From: Simon Davis
Sent: 01 March 2019 12:45
To: 'Stephen Brooker' <stephen.brooker@walsingplan.co.uk>
Cc: Rob Murgatroyd <rob.murgatroyd@walsingplan.co.uk>
Subject: RE: BR/326/18/PL - The Royal Hotel, The Esplanade, Bognor Regis

From: Stephen Brooker [REDACTED]
Sent: 25 January 2019 16:52
To: Simon Davis <Simon.Davis@arun.gov.uk>
Subject: BR/326/18/PL - The Royal Hotel, The Esplanade, Bognor Regis

DRAWING TITLE Proposed Second Floor Plan

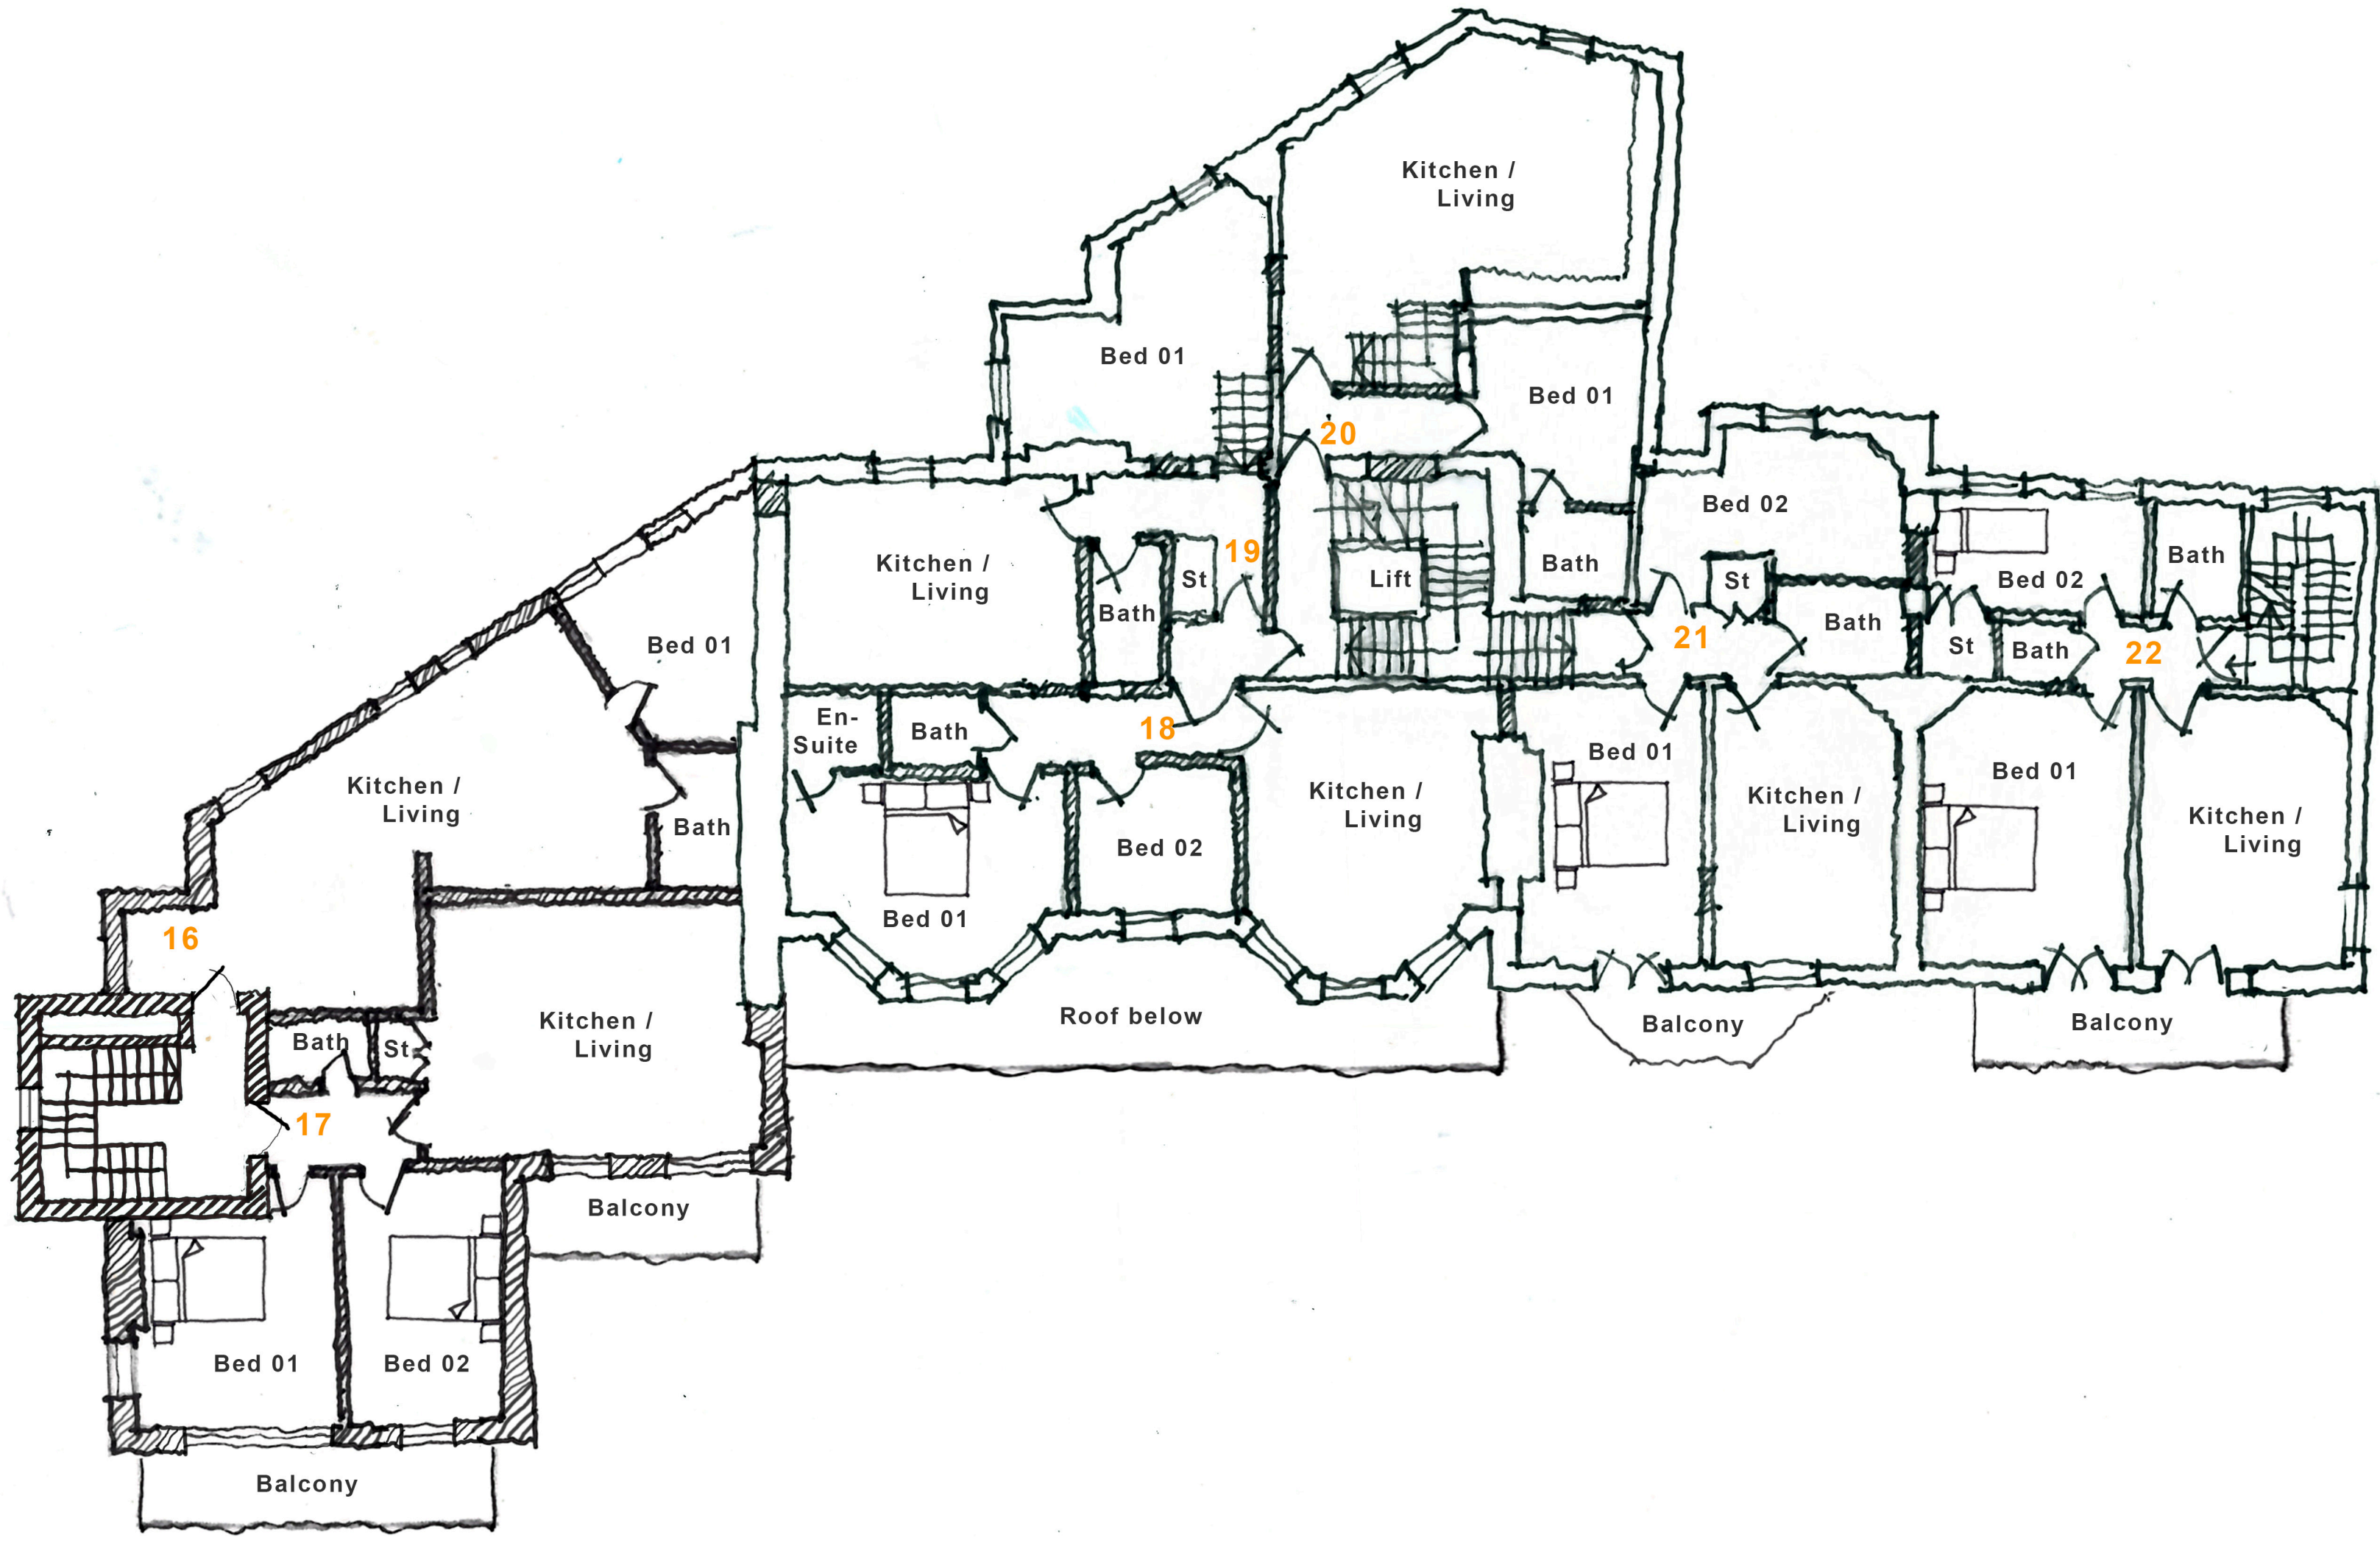
One thing he mentioned (and was going to be in his response) was a discrepancy with the plans regarding the dormers on the flank roof planes of the main roof. I think from memory that there are some elevations and possibly the upper floor plan where one or both of these are not shown. I also think he had said that some of the drawings have not made it onto our website. I can't compare to the file at present as Martyn has it but I can't see a third floor plan or an east elevation on the plans we have uploaded. If these are a thing, can you email to me and I'll fix the public viewer. Please also have a look into the dormer issue.
